# **A46 Newark Bypass**

**Scheme Number: TR010065**

## **Statement of Common Ground with Newark and Sherwood District Council 'NSDC'**

**Statement of Common Ground with  
Newark And Sherwood District Council**

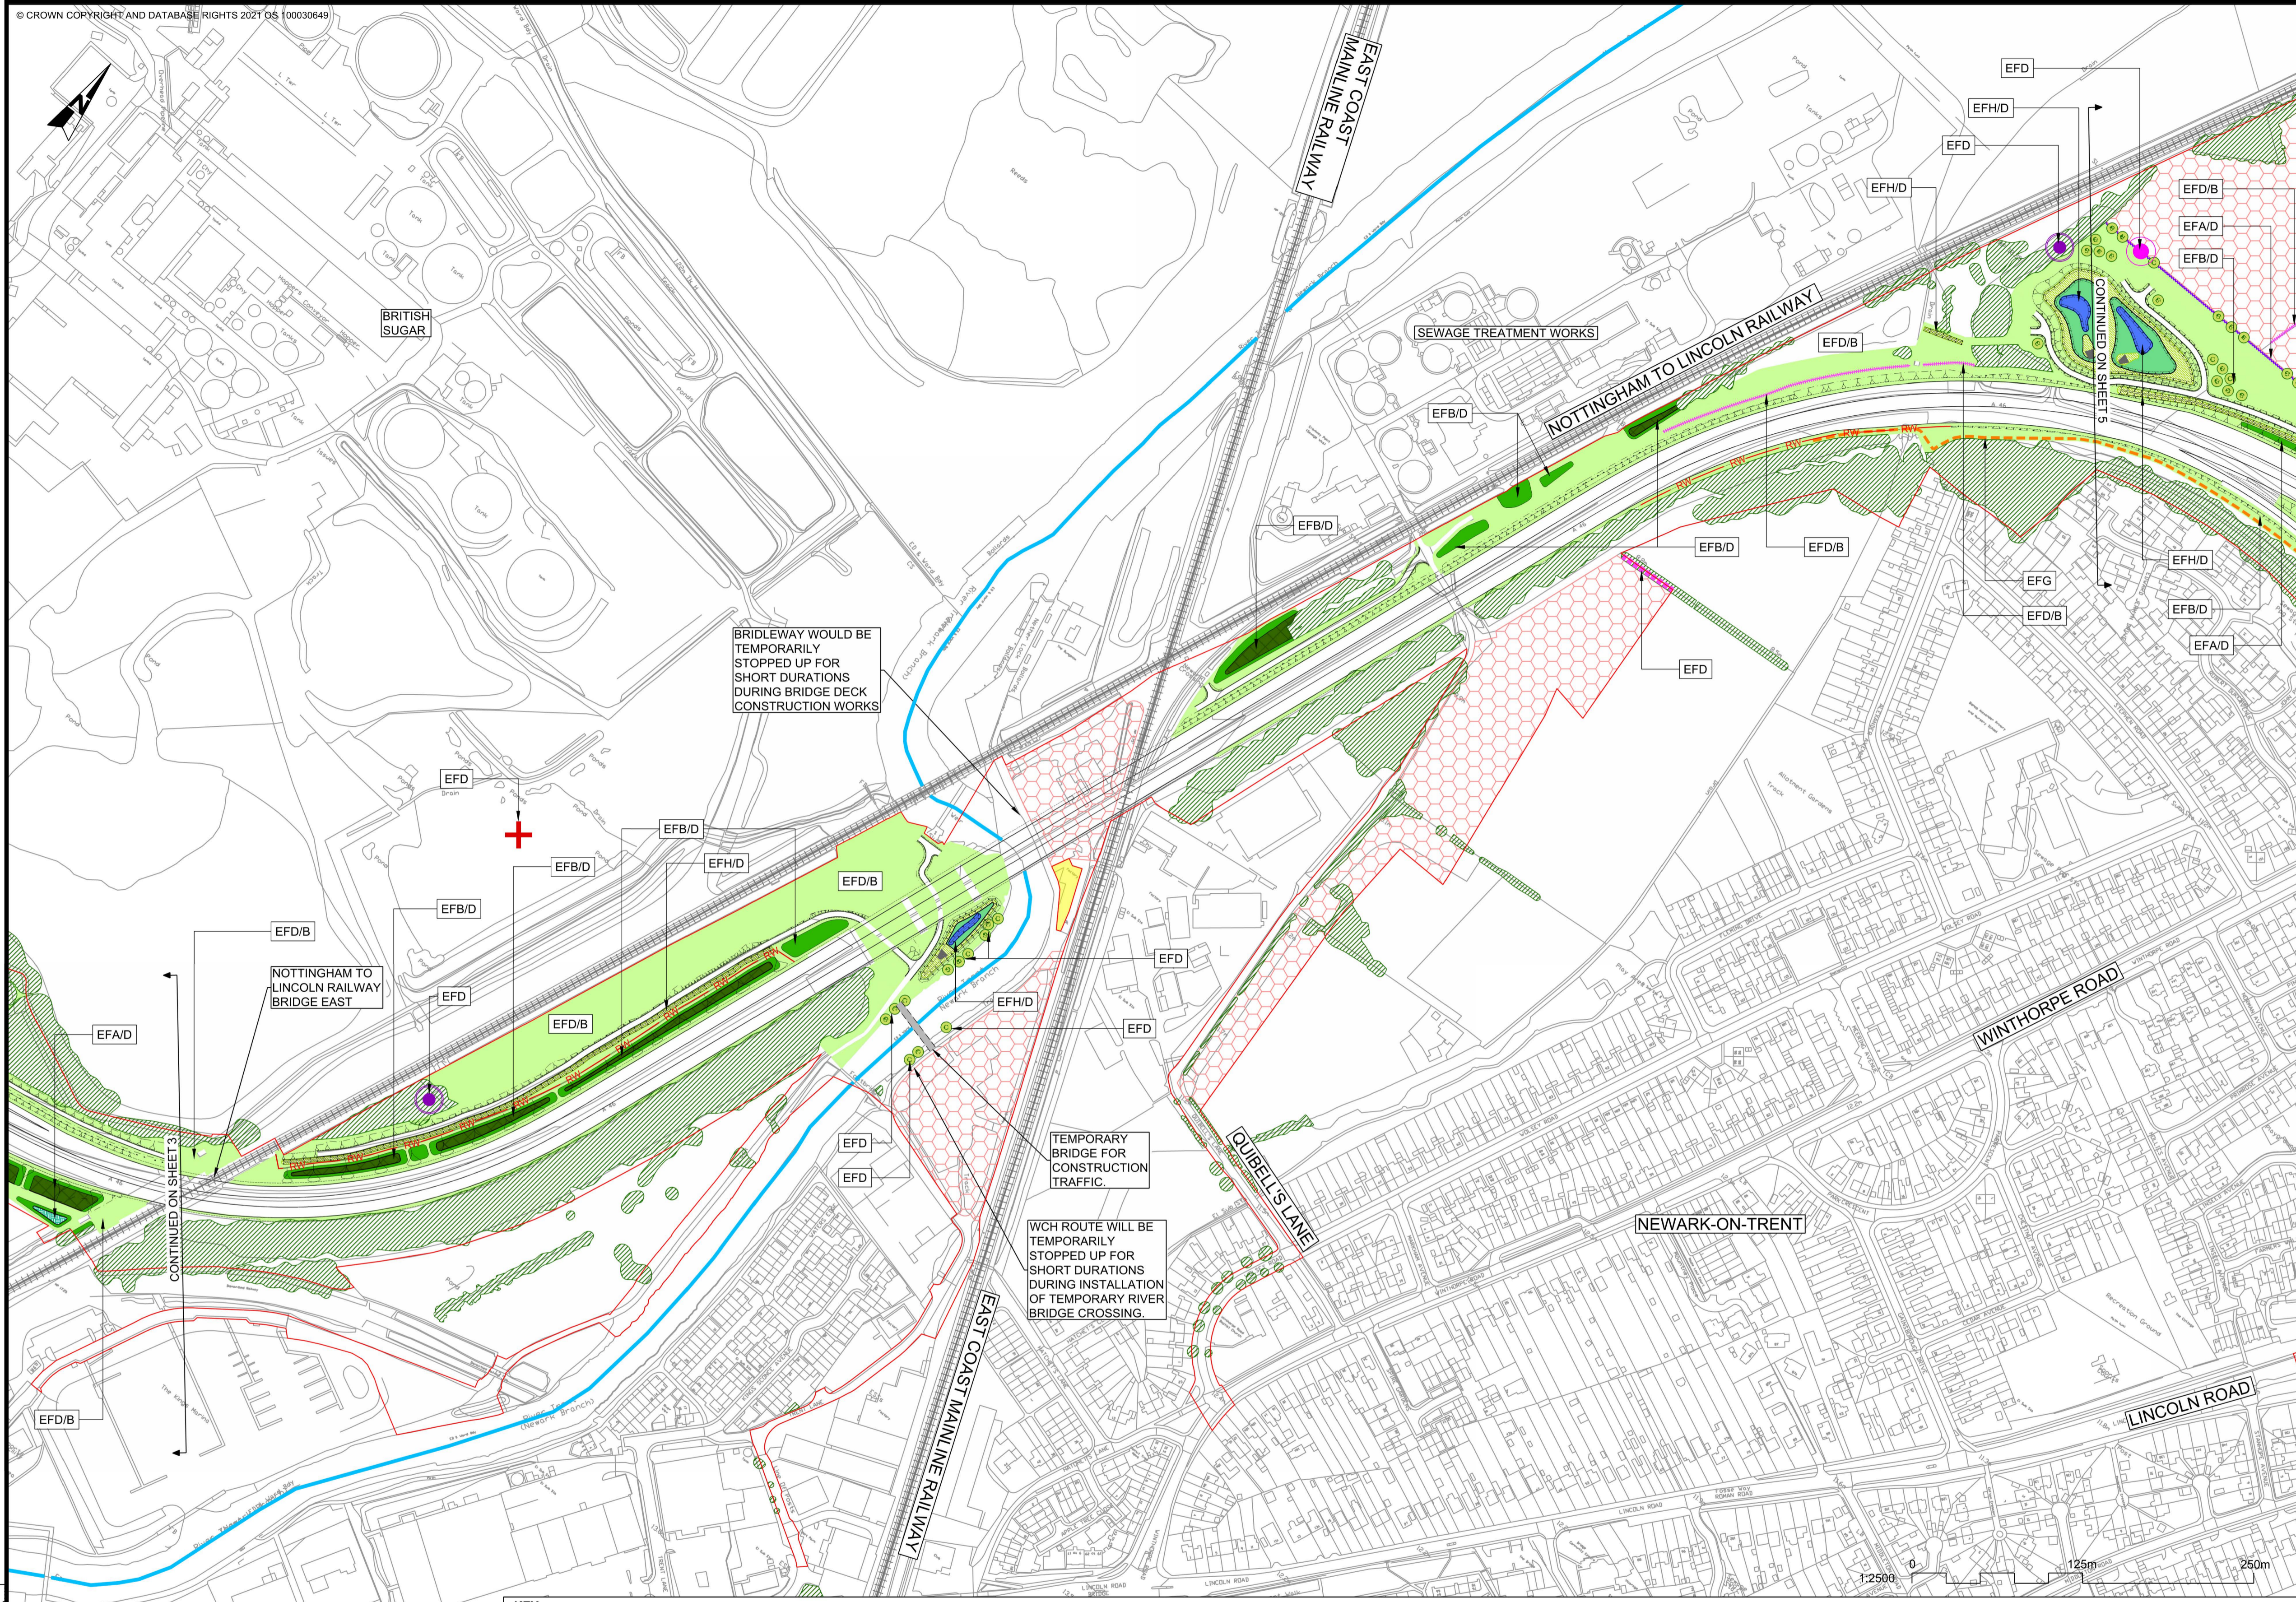
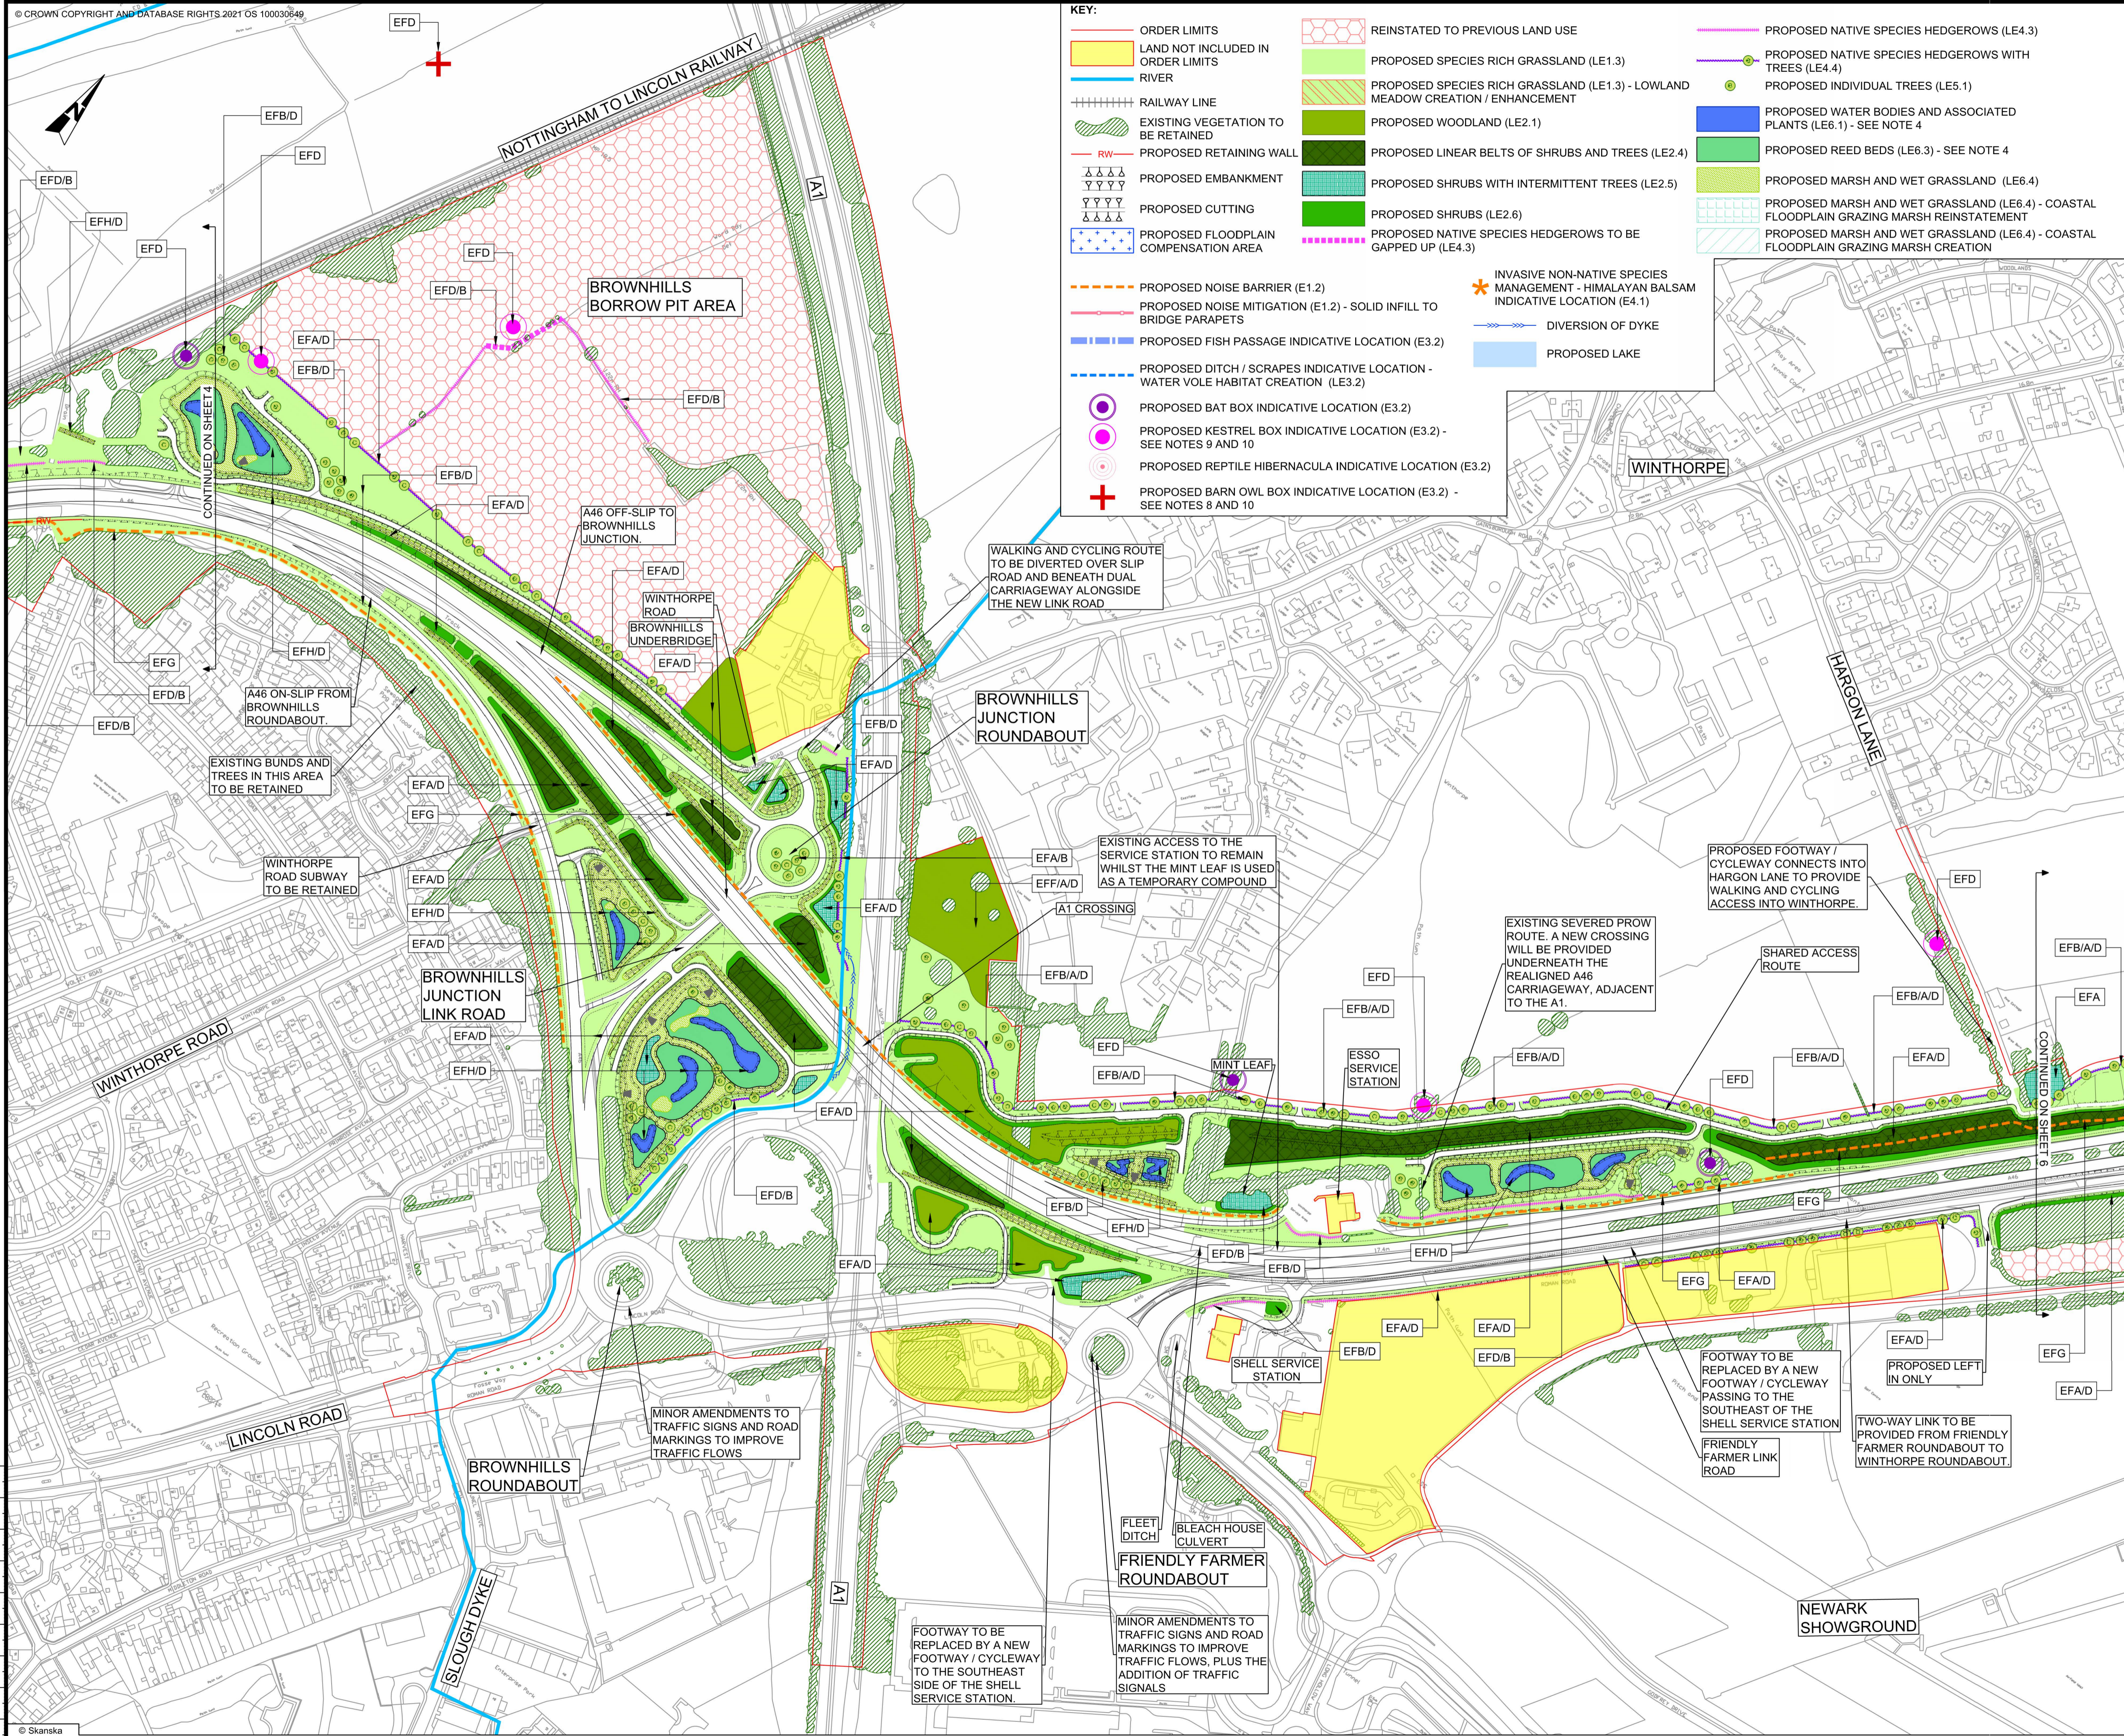
12.	Design (including justification for any flexibility being sought)	<p>Chapter 2 The Scheme of the Environmental Statement [APP-046]</p> <p>6.2 Environmental Statement - Figure 2.3 Environmental Masterplan [AS-026]</p>	<p><b><u>Cattle Market flyover</u></b></p> <p>On the fly-through video the structure of the elevated over-pass at the Cattle Market junction appears as a stark and imposing concrete structure. This may be in part due to the animation which depicts it as being very bright in colour and therefore standing out vividly. The Council would want to understand proposals to ensure the visible impact of the final structure is minimised and/or mitigated as far as practicable.</p> <p>03/02/2025 – Although this structure is now understood we still continue to raise concern with the impact the structure would have on the surrounding area.</p>	<p>Consideration has been given to the aesthetic finish of the structure during the design development to help to reduce the visual prominence of the structure and to reflect finishes on existing structures such as that of Smeaton's Arches just to the north of the new junction. Further details of these can be found within Chapter 2 The Scheme of the Environmental Statement [APP-046] and 6.2 Environmental Statement - Figure 2.3 Environmental Masterplan [AS-026].</p> <p>Planting of trees and shrubs has also been considered and incorporated wherever feasible to help break up the visual mass of the structure, with planting softening the built form and aiding screening over time, particularly from properties such as those in Sandhills Park affording near distance views.</p> <p>The assessment of landscape and visual effects and associated design and mitigation measures are described in 6.2 Environmental Statement - Figure 2.3 Environmental Masterplan [AS-026] and presented in 6.2 Environmental Statement - Figure 2.3 Environmental Masterplan [APP-026].</p> <p>Part of the Detailed Design process will be to define the finish of the retaining walls forming the Cattle Market Flyover. This will be a masonry type façade and not a bare concrete finish.</p>	Not Agreed	20/02/2025
